Application by Highways England for M54 to M6 Link Road

The Examining Authority's written questions and requests for information (ExQ1)

Issued on 20 July 2020

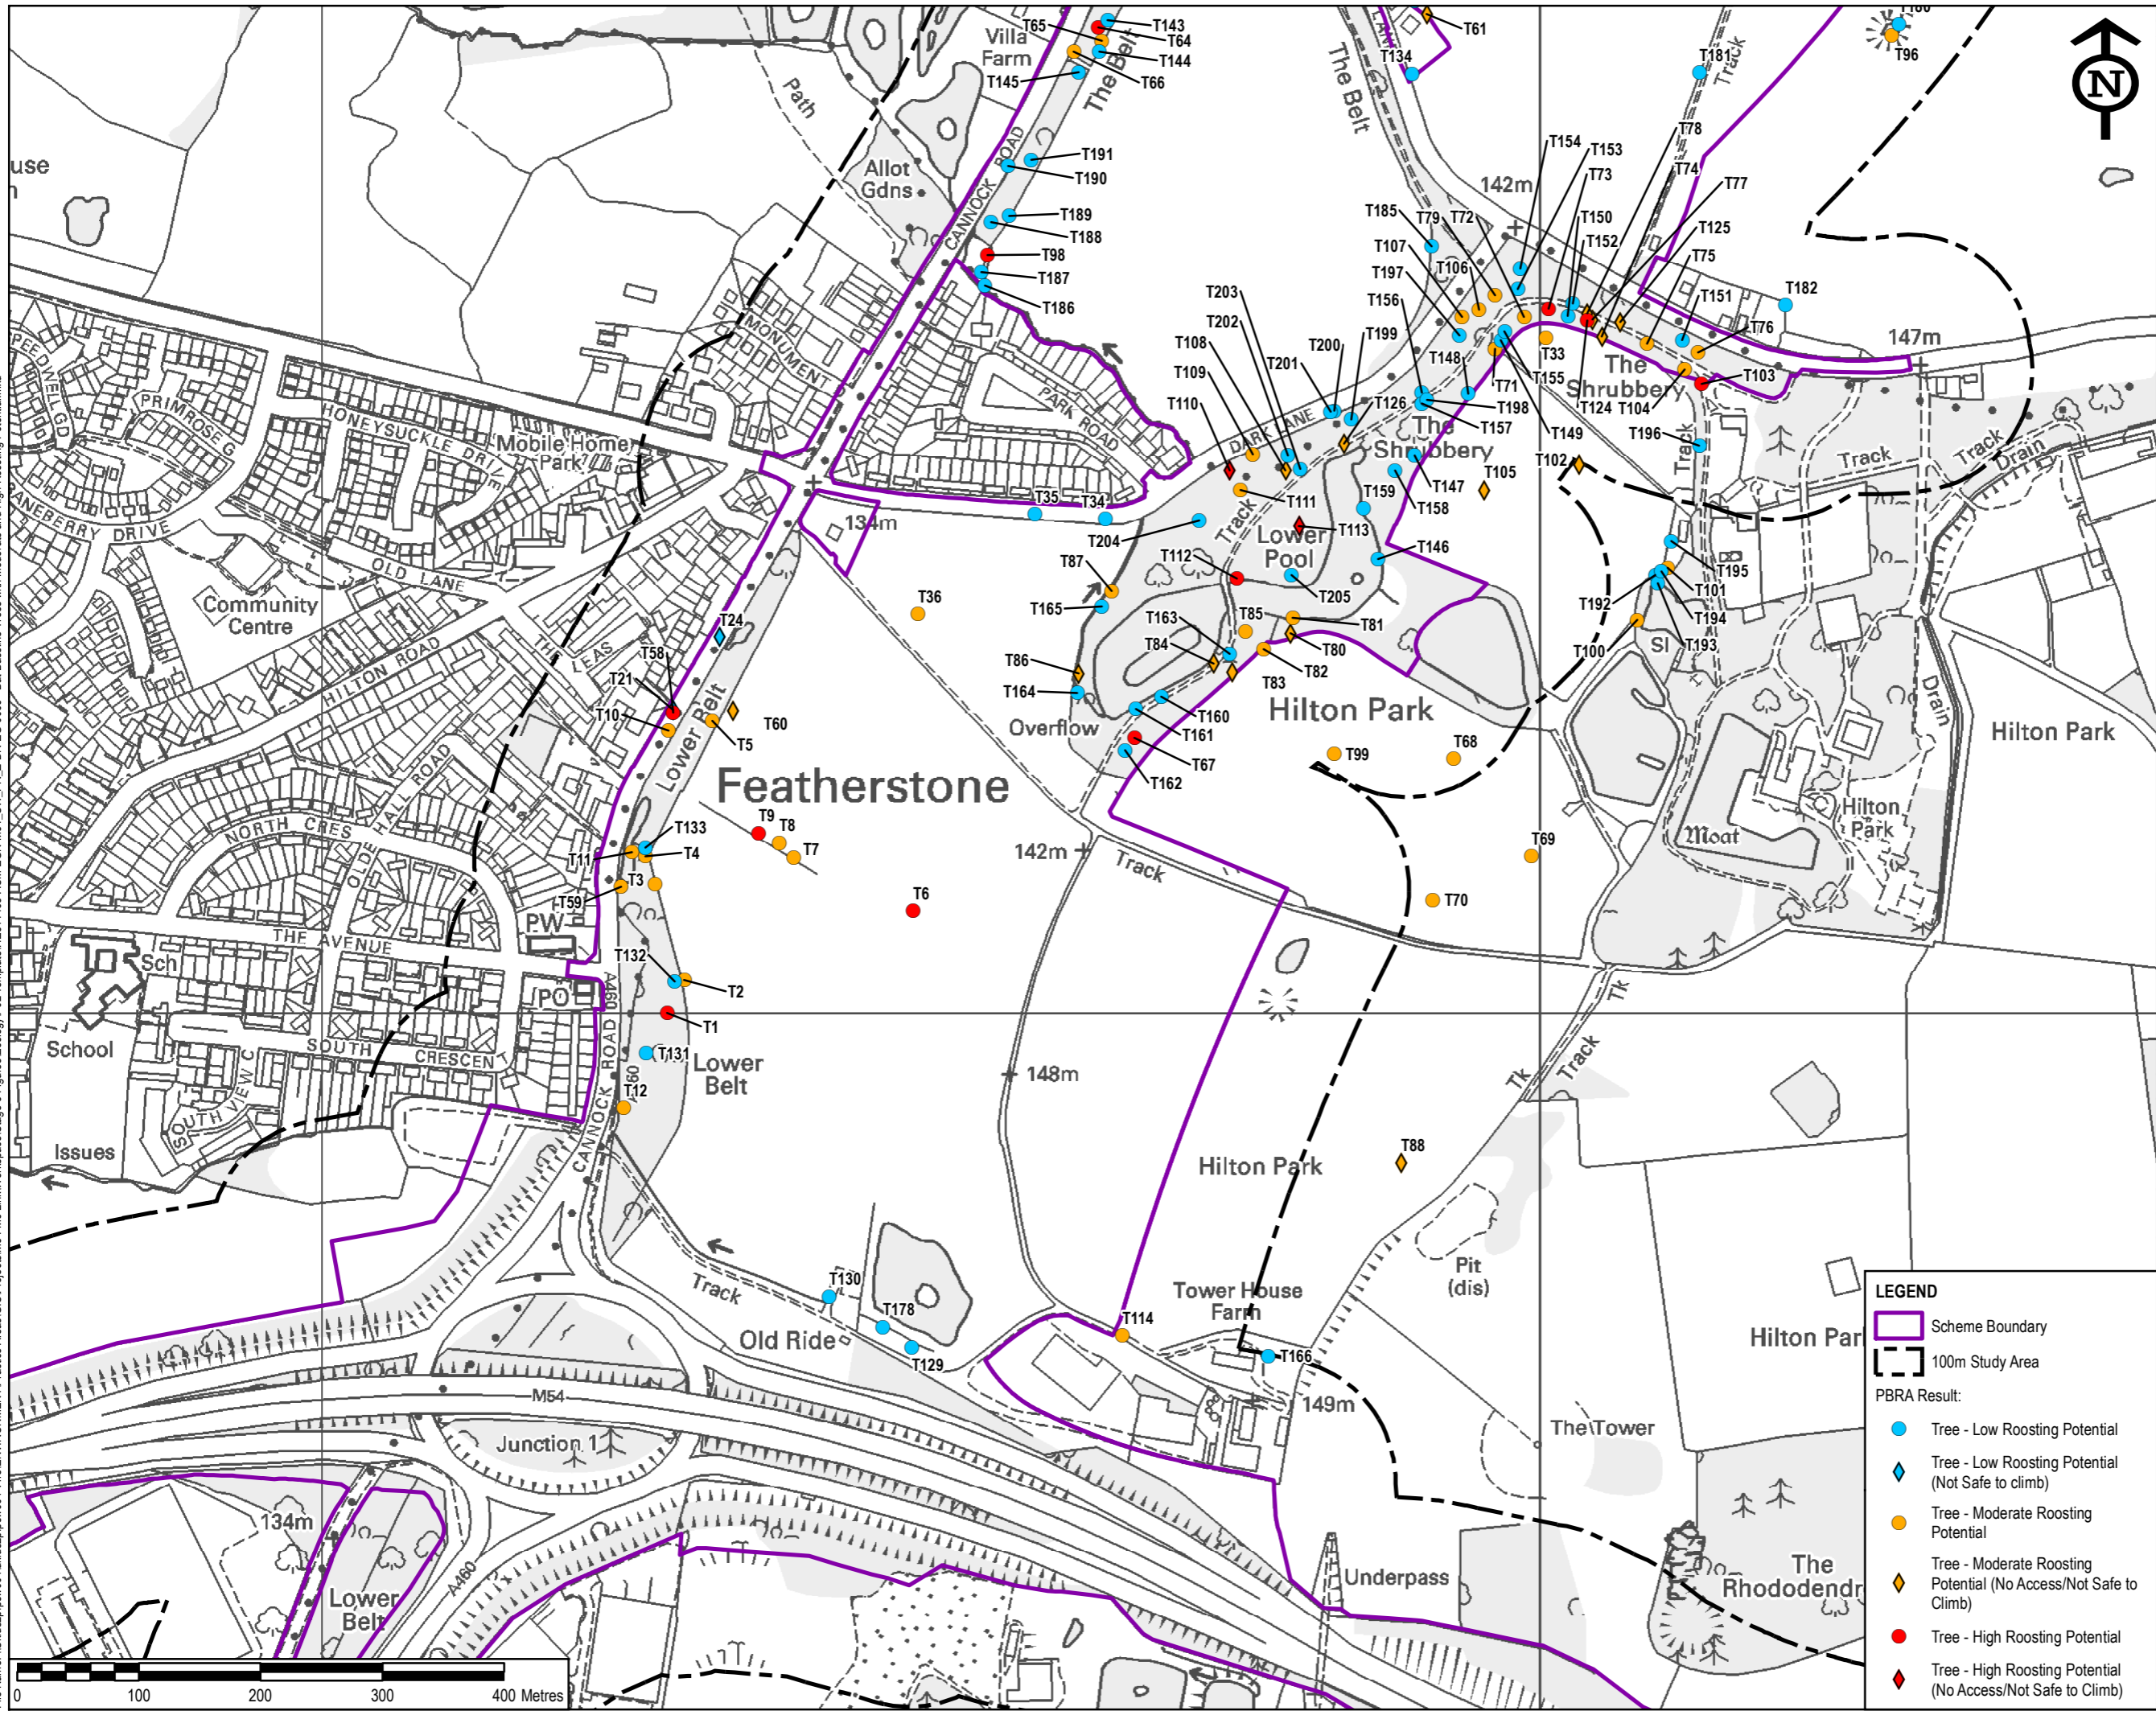
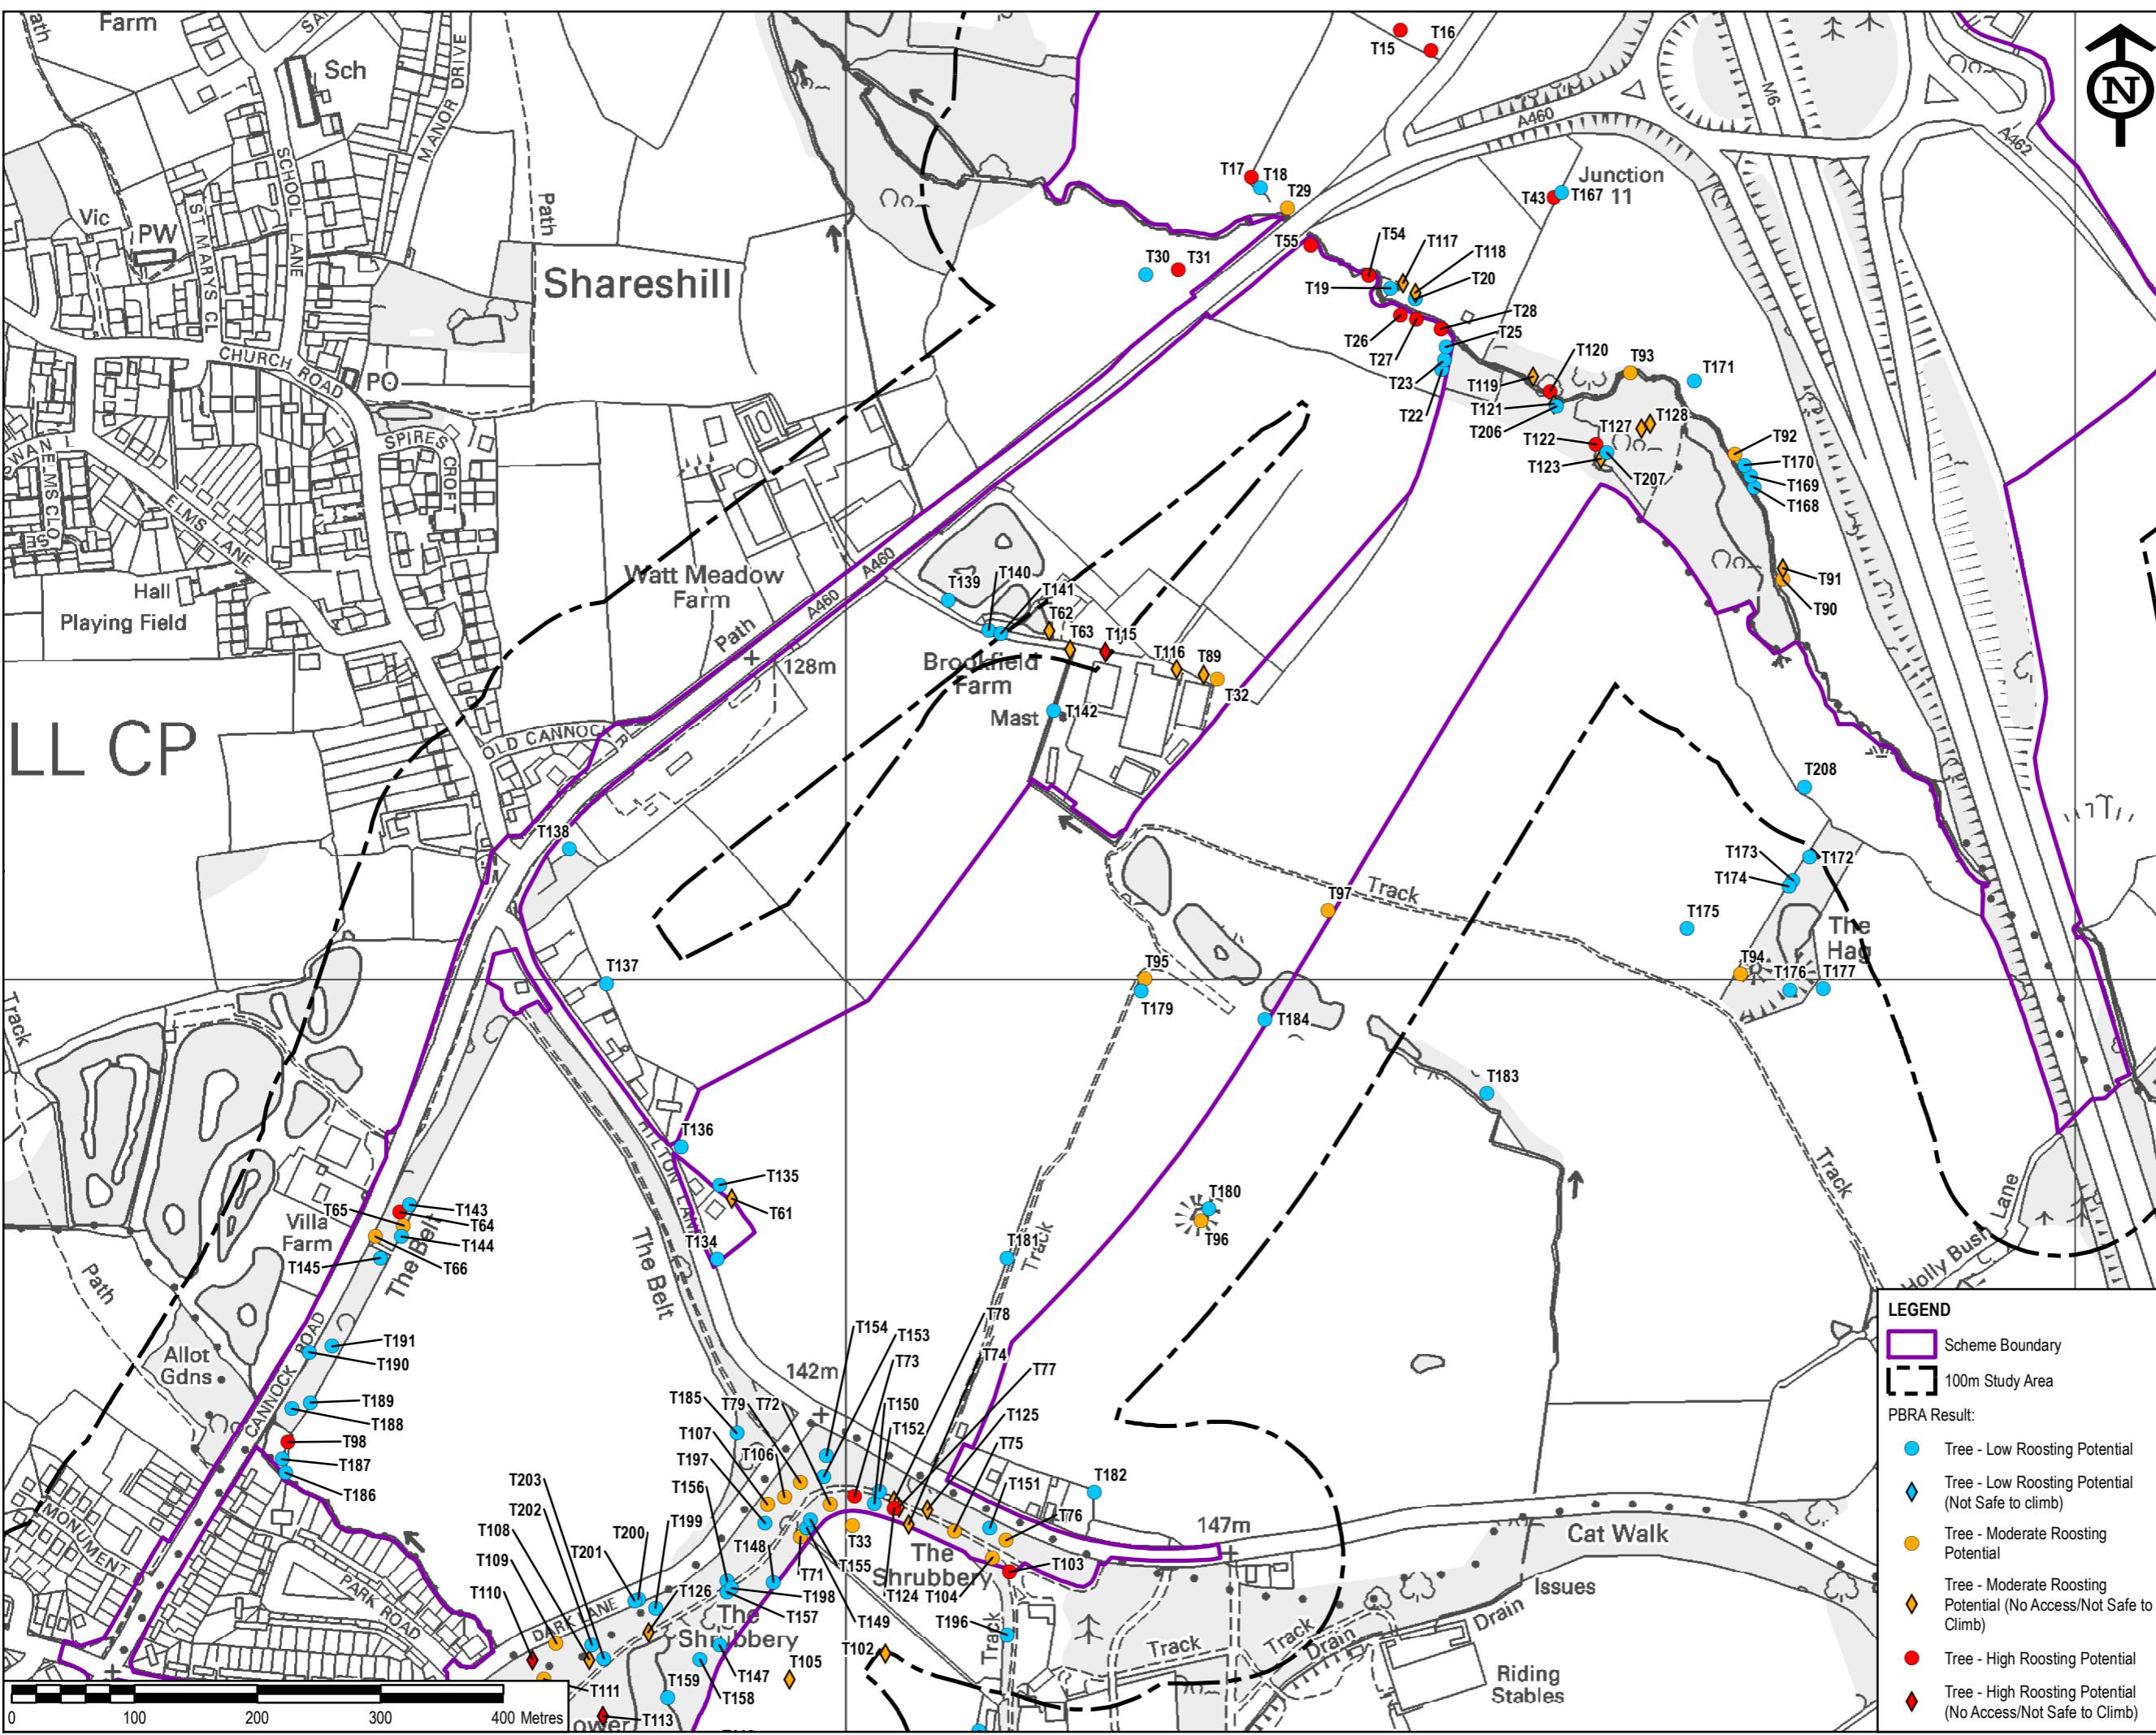
ExQ1	Question to:	Question:
		context?
1.3.4.	The Applicant	<p>Bats Paragraph 8.6.28 of Chapter 8 of the ES [APP-047] indicates two bat roosts within the boundary of the Proposed Development. However, in Figure 8.14 [APP-118] these two trees (T70 and T112) are given different classifications. Could this discrepancy be explained?</p>
